Oxfordshire County Council's response to Cherwell District Council's consultation on amended application for Phase One North West Bicester Eco-town (No: 10/01780/HYBRID)

1. Based on the amended information in the application, it is recommended that the County Council should submit an **objection** to the proposals to Cherwell District Council (CDC).

Daniel Round and Linda Currie
26 May 2011

Play Provision Strategy

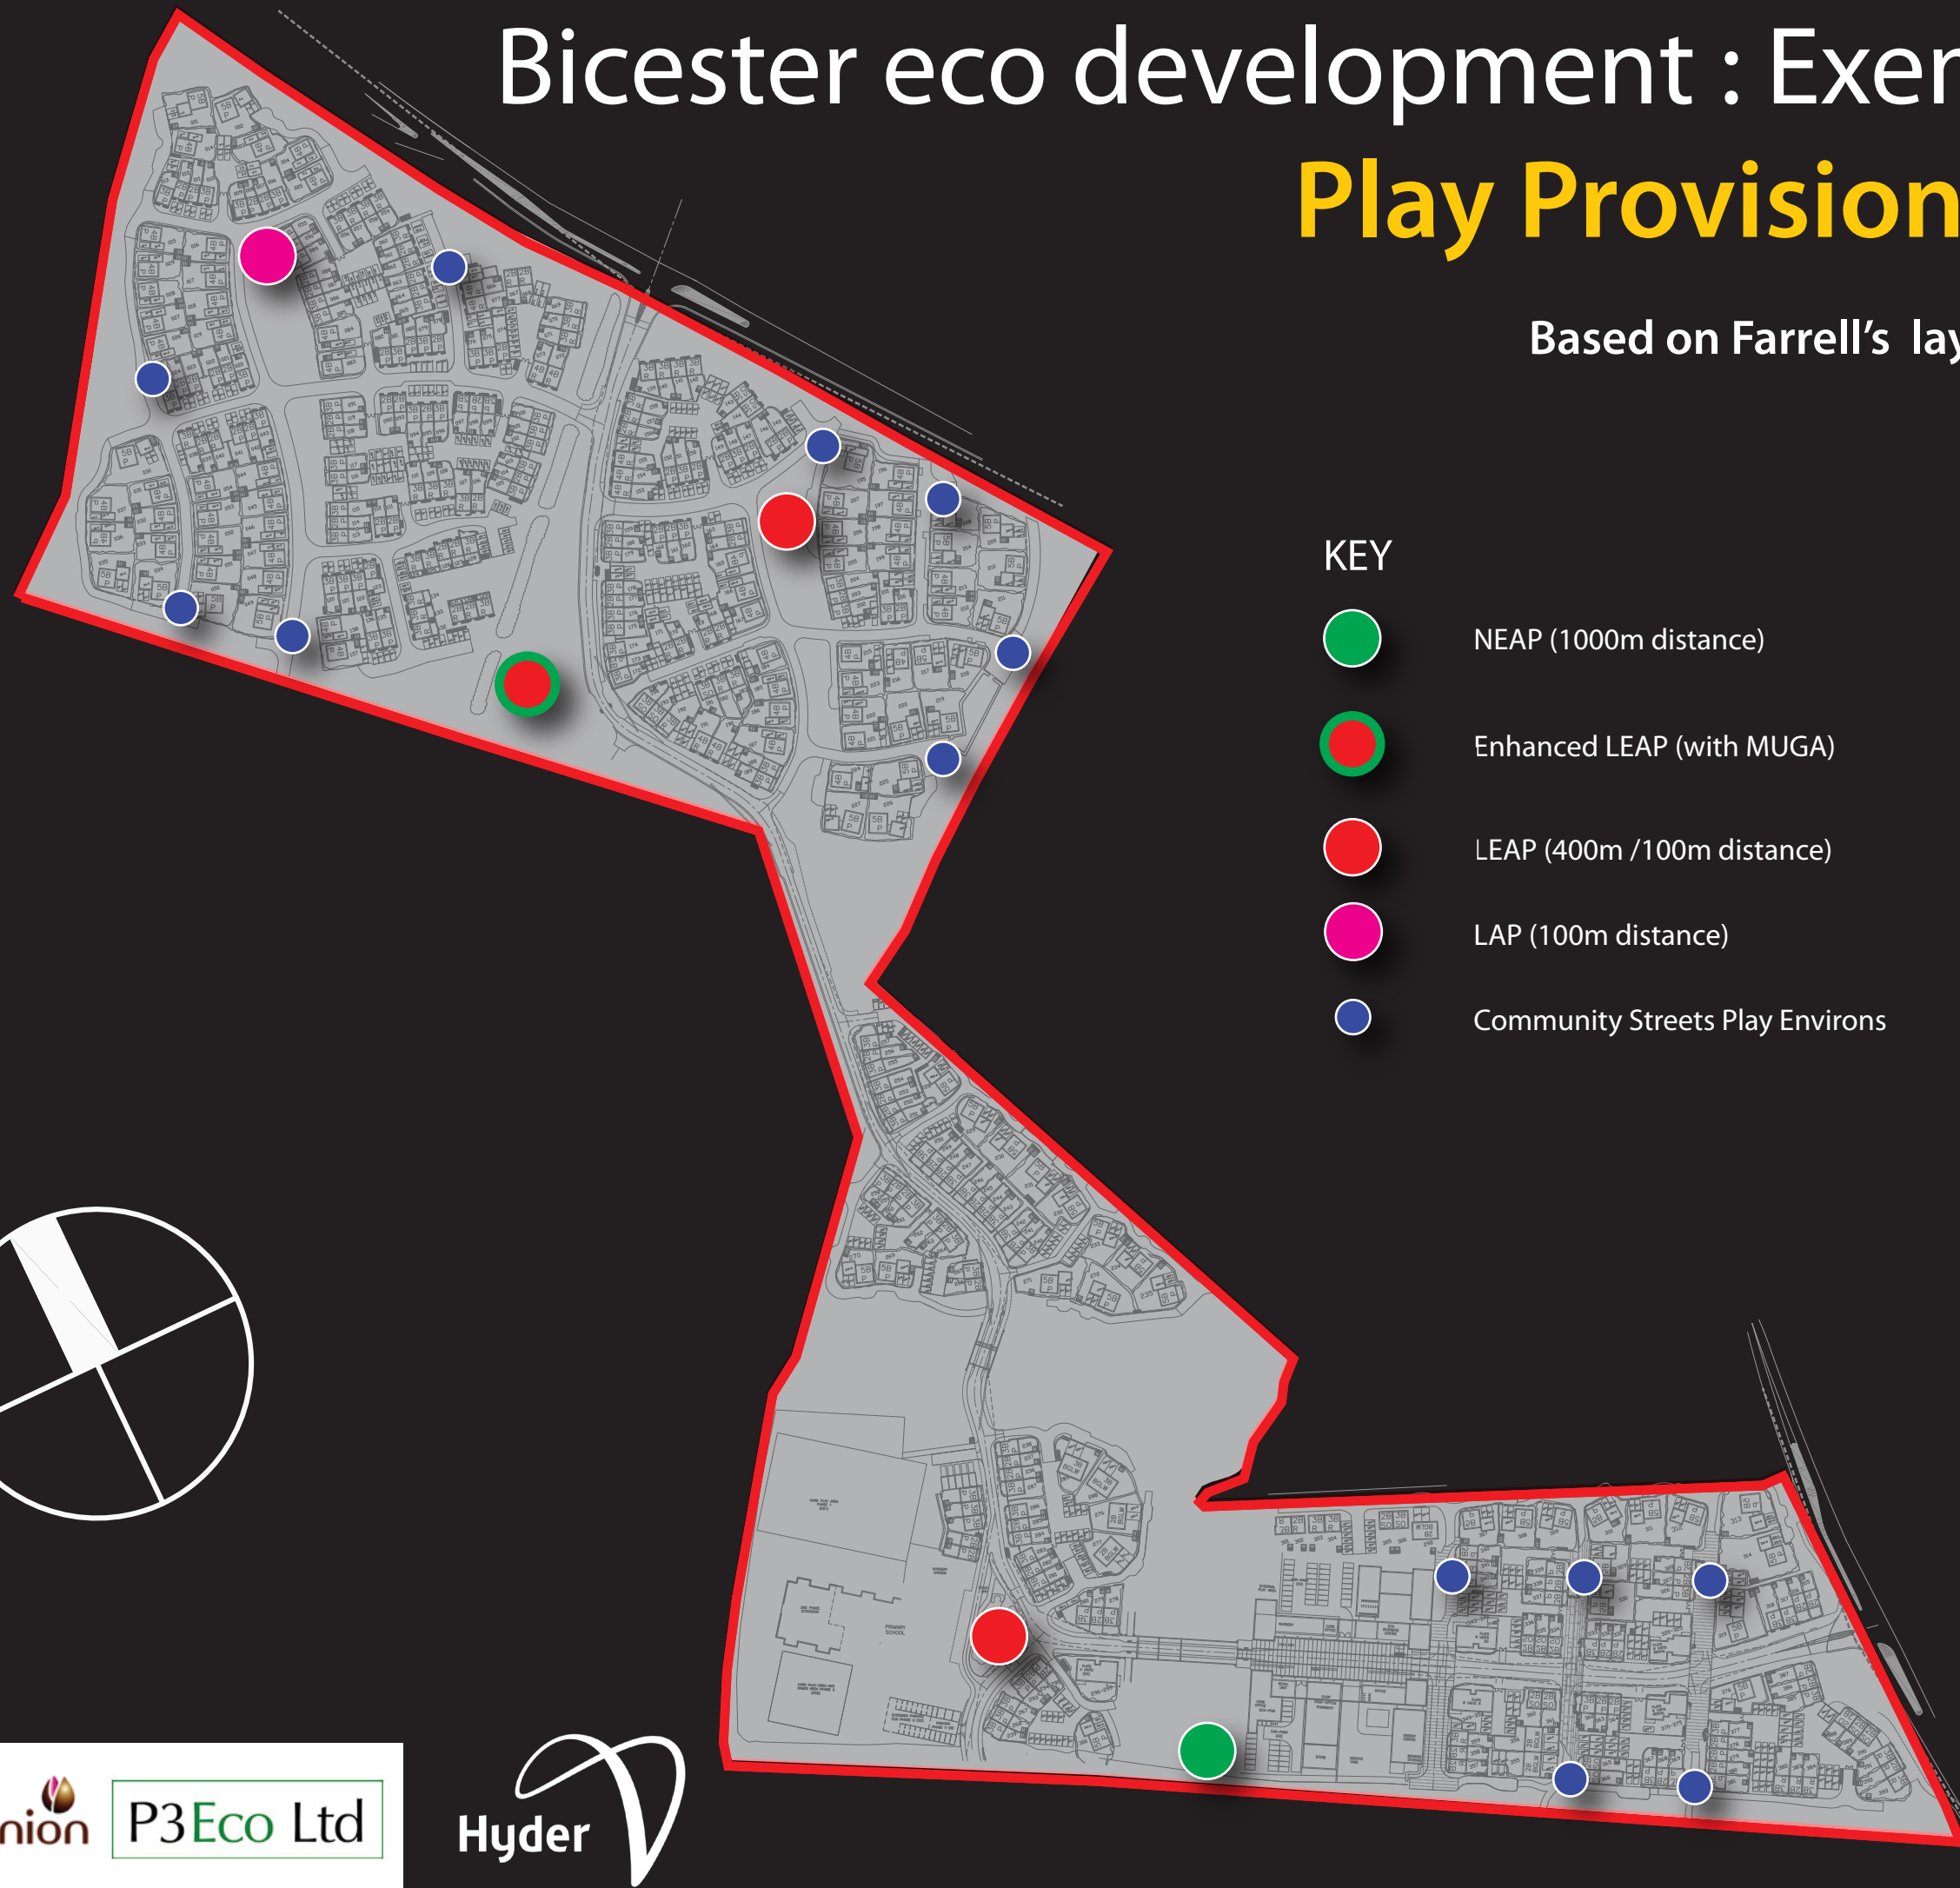
- a) Further information is provided that demonstrates the development will deliver a net gain in bio-diversity; this should include a draft management plan;
- b) Changes to the Masterplan are made to remove encroachment of the proposed play area into the corridor of the River Bure and to redesign the bridge to maximise space underneath for commuting bats;
- c) The S106 agreement includes, off site compensation for residual impacts and mechanisms and funding for management of green space in perpetuity

Bicester eco development: Exemplar Lighting Strategy Diagram

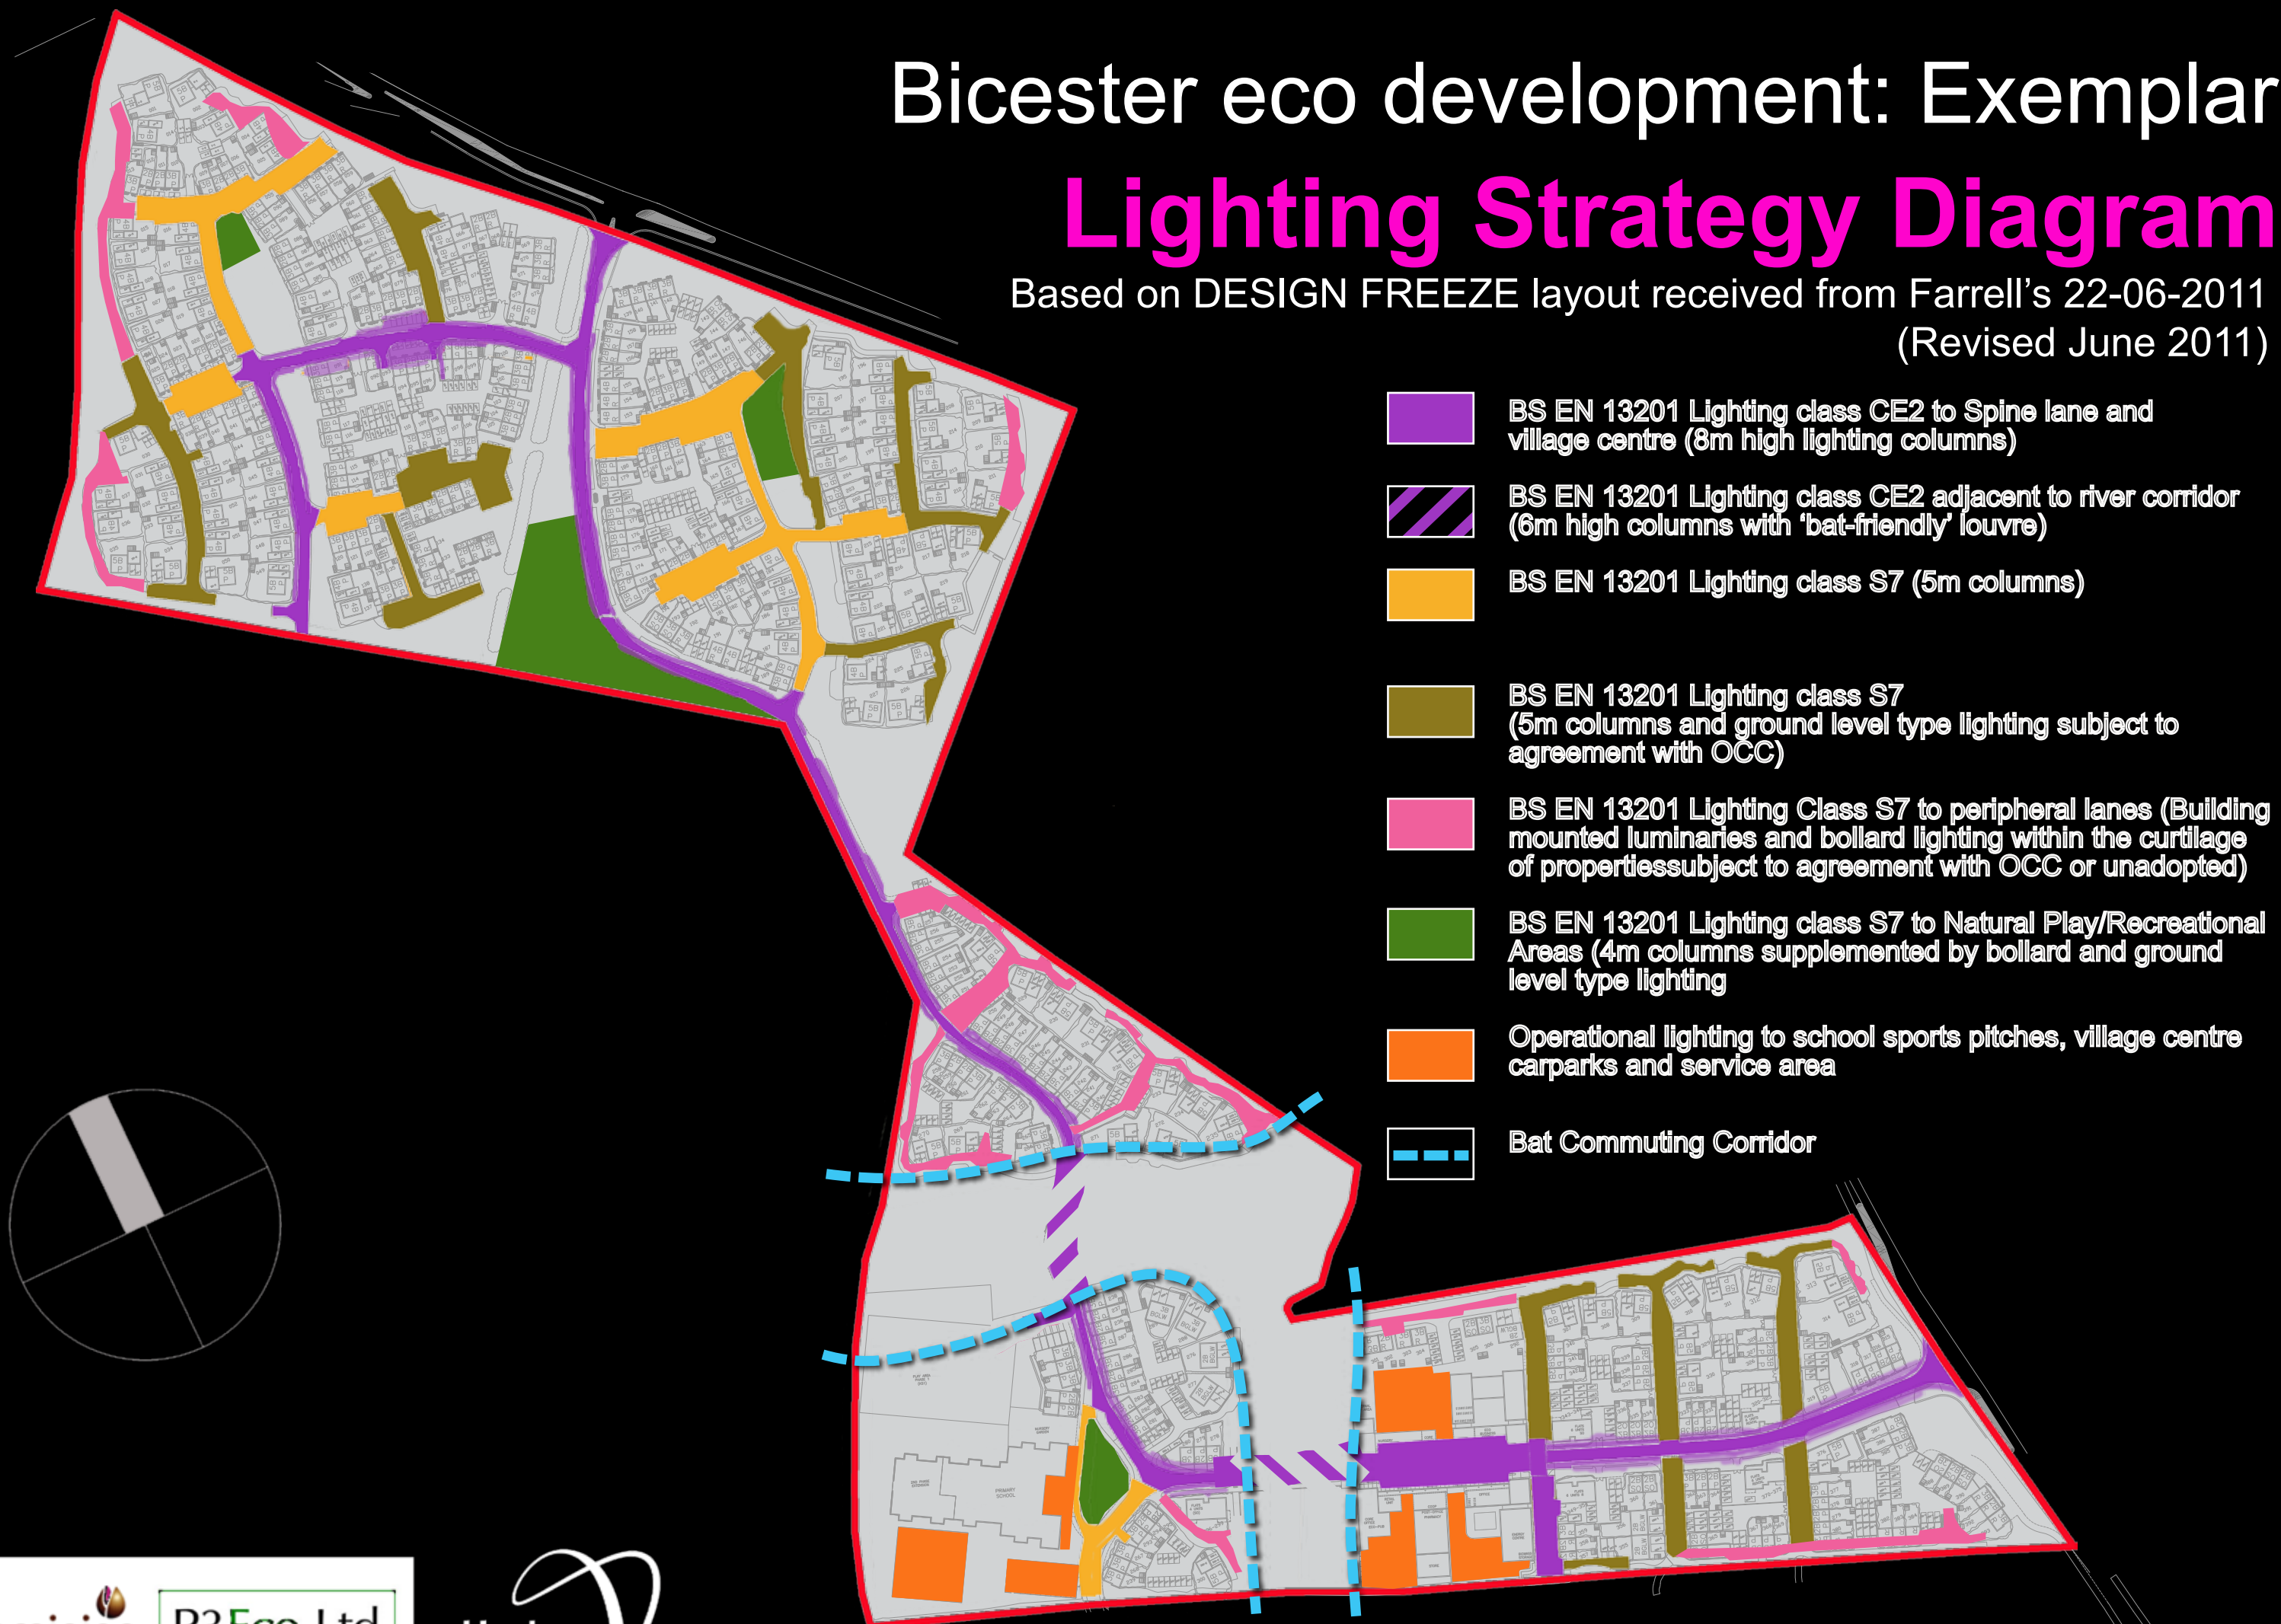
37. Following our initial comments on the drainage proposals, improvements have been made to the strategy. However, further information is required before the officers can assess whether it meets the standards for Sustainable Drainage System (SuDS). More detailed information is also required before officers are able to agree to the lighting proposals.
38. **Recommendation: OBJECT**, unless further information is submitted to ensure that the drainage proposals meet the SuDS standards and the County Council's lighting standards.
